DEPARTMENT OF PARKS AND COMMUNITY SERVICES

February 8, 2024

Subject: Ivilo Final Plat (SF245)

The El Paso County Parks and Community Services Department has reviewed the development application for the Ivilo Final Plat. These preliminary comments are being provided on behalf of El Paso County Parks. This final plat application, along with the following comments and recommendation will be presented to the El Paso County Park Advisory Board for endorsement on February 14, 2024.

Final Plat
VILO HEIGHTS SUBDIVISION

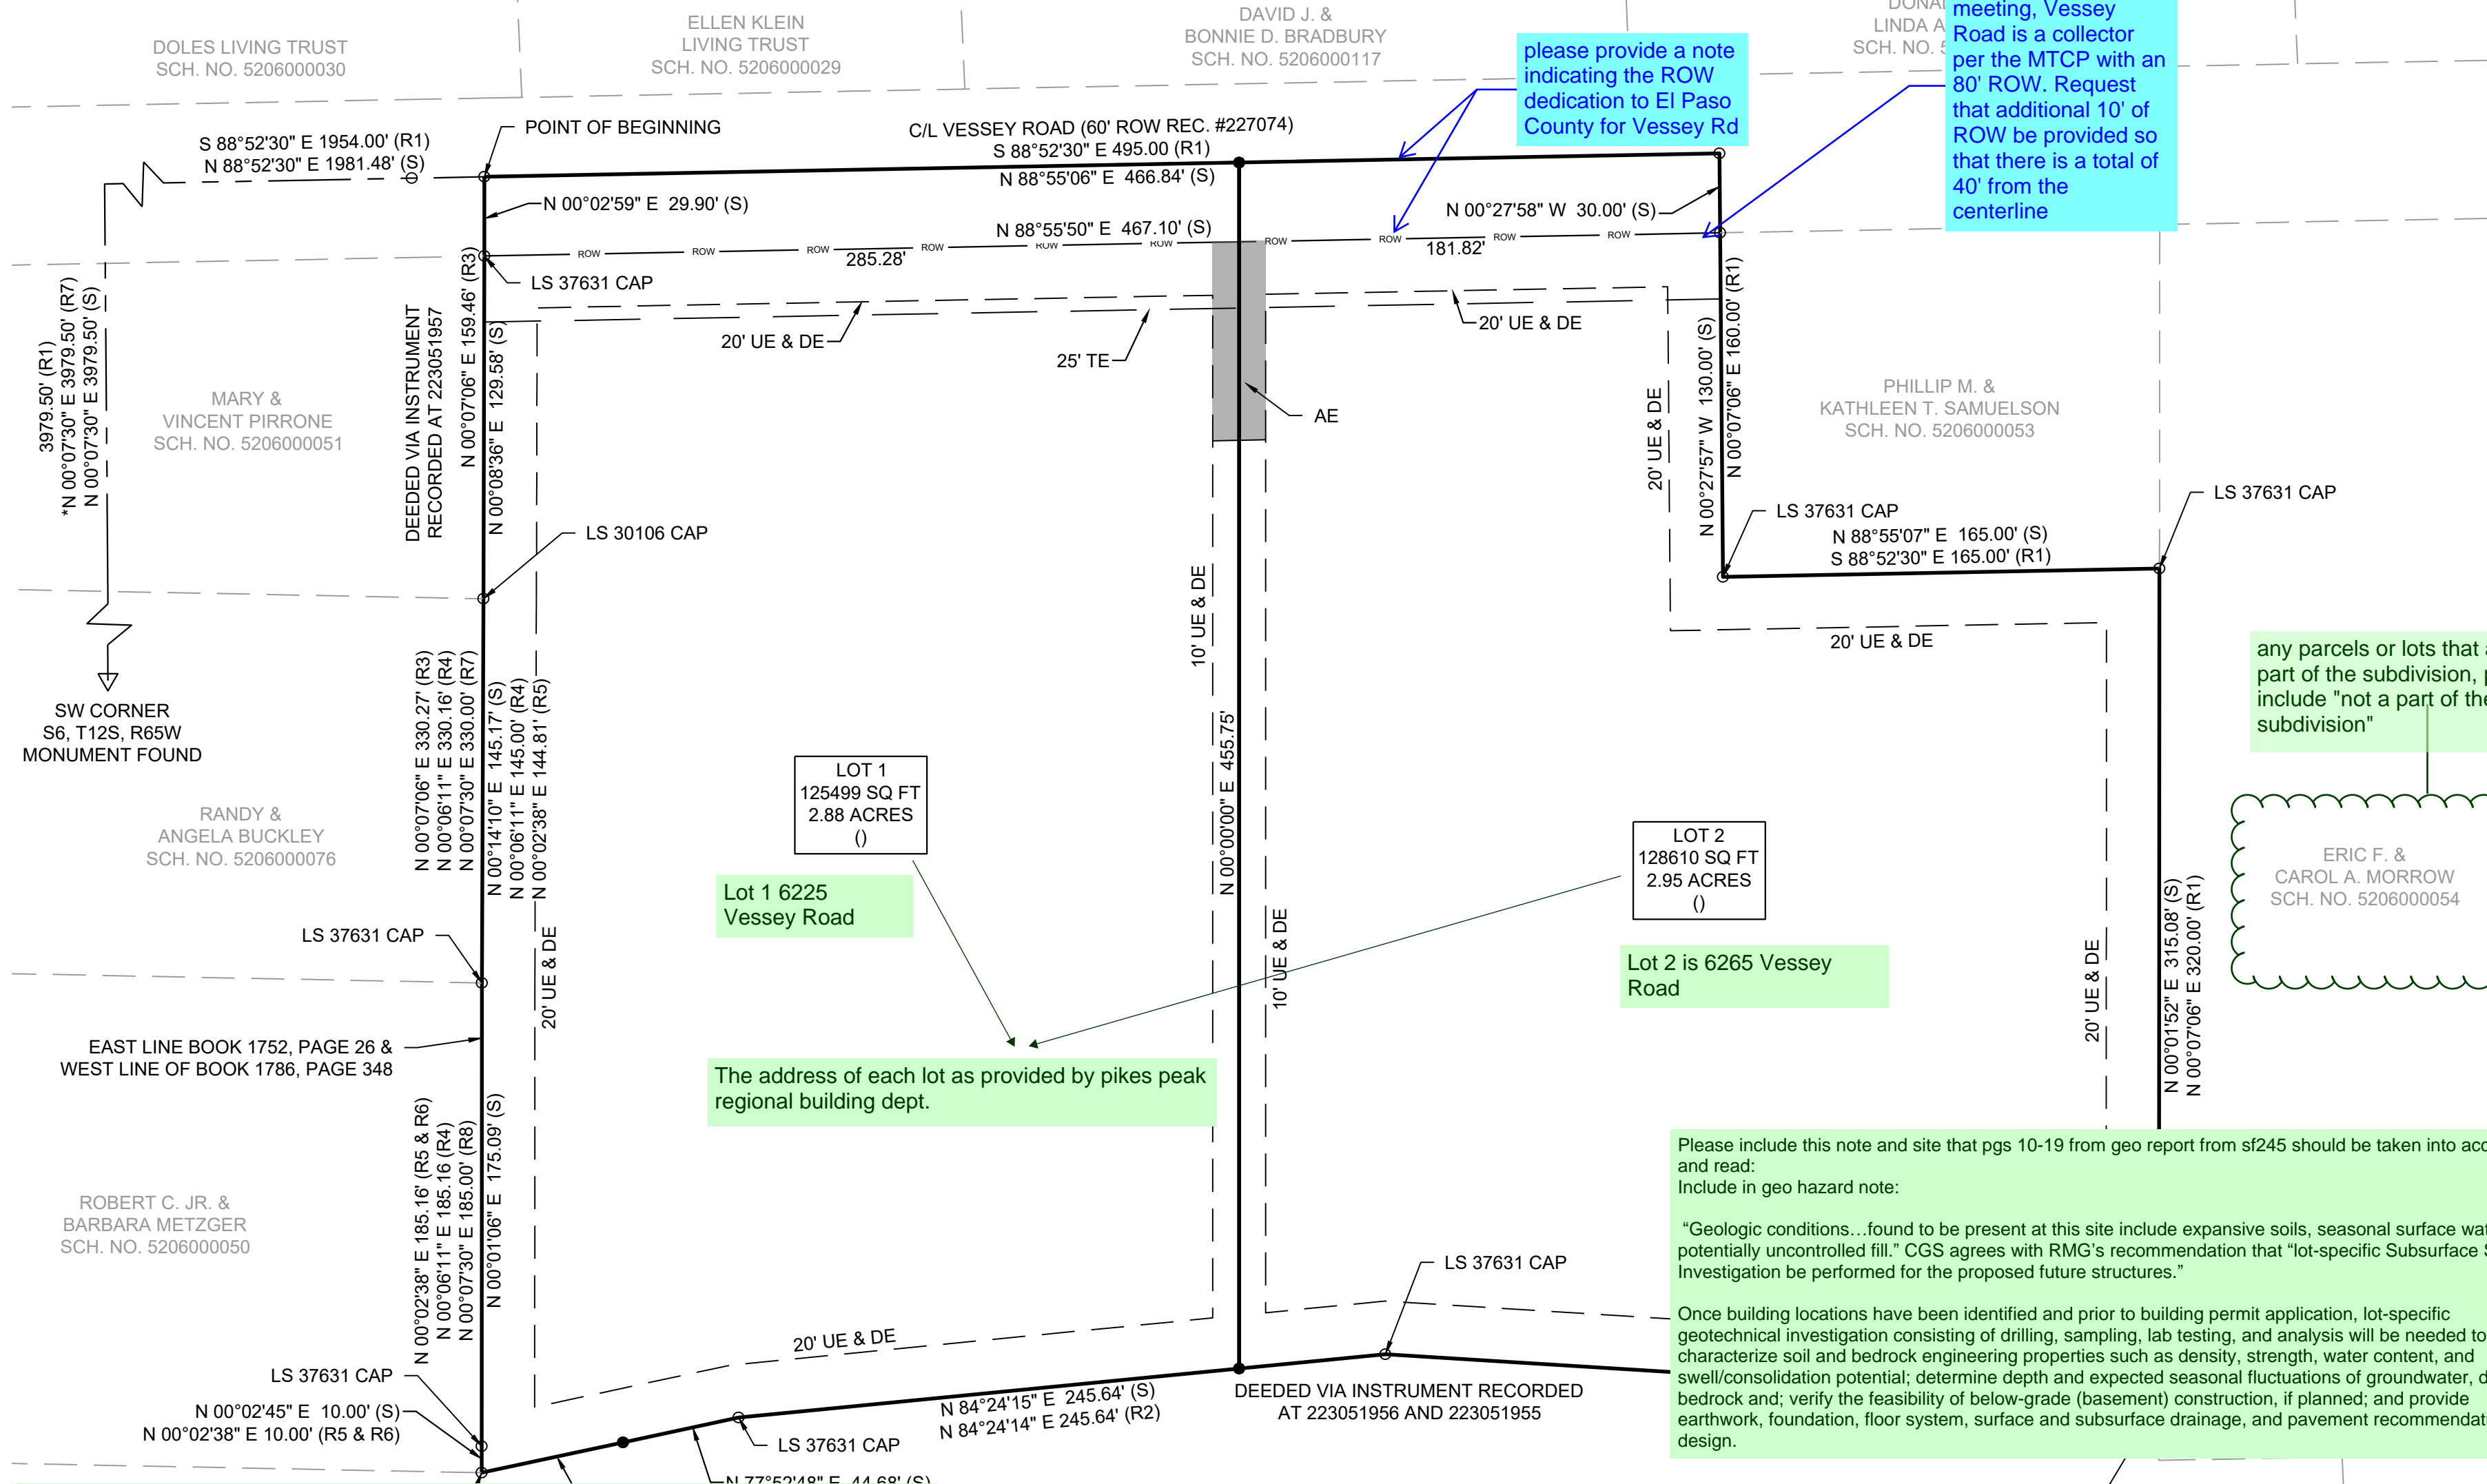
County Parks requests trail easements where development projects impact proposed County trails. As it pertains to the future minor subdivision application, the County will request that the landowner provide a 25-foot public trail easement along the north side of the proposed subdivision along Vessey Road to allow for the construction and maintenance by El Paso County of a the Palmer Divide Regional Trail, and this easement shall be shown and dedicated to El Paso County on the Final Plat.
